The Secretary
NSW Department of Planning, Industry & Environment

8 August 2022

I refer to the Department's email of 14 July 2022 regarding the exhibition of the Environmental Impact Statement (EIS), for State Significant Development SSD-33042483 Manildra - Port Kembla Bulk Liquid Terminal for 'Construction and operation of a bulk liquid fuel terminal, comprised of: x6 four megalitre (ML) potable ethanol storage tanks; x2 pipelines (300 mm diameter); admin buildings, gantry structures, landscaping & carpark' at Foreshore Road, Port Kembla (Lot 6 DP 1236743, Lot 2 DP 1182823) in the Wollongong City Council Local Government Area (LGA). Submissions need to be made to the Department by 15 August 2022.

Figure 49: Approved Electrical Infrastructure Upgrades

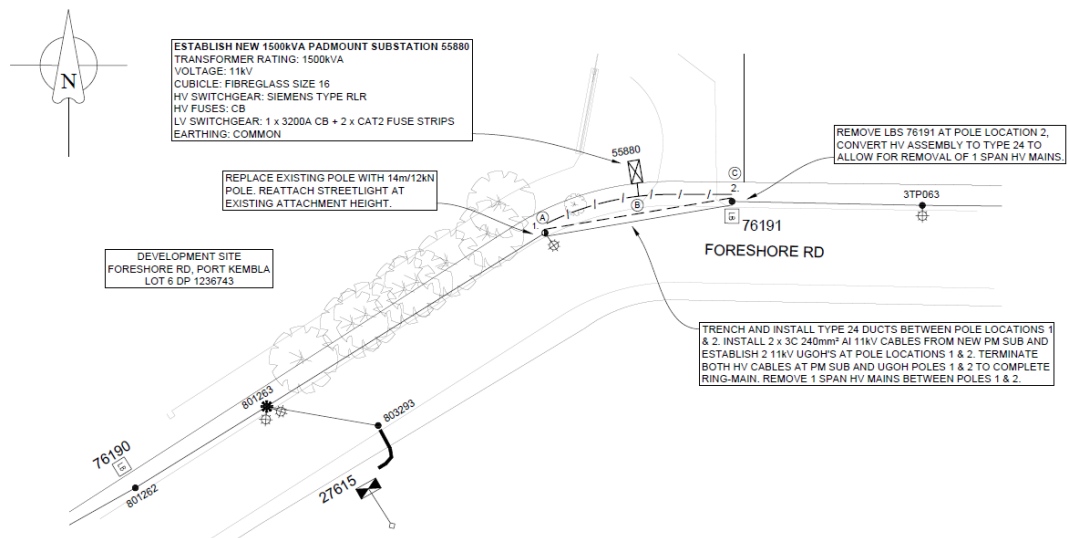
The new padmount substation is shown in the following extract of the Development Drawings. Any required padmount substation/s will need to be located within the property (in a suitable and accessible location) and be protected (including any associated cabling) by an easement and associated restrictions benefiting and gifted to Endeavour Energy. Please refer to Endeavour Energy's Mains Design Instruction MDI 0044 'Easements and Property Tenure Rights'.

Generally it is the Level 3 Accredited Service Provider's (ASP) responsibility (engaged by the developer) to make sure substation location and design complies with Endeavour Energy's standards the suitability of access, safety clearances, fire ratings, flooding etc.
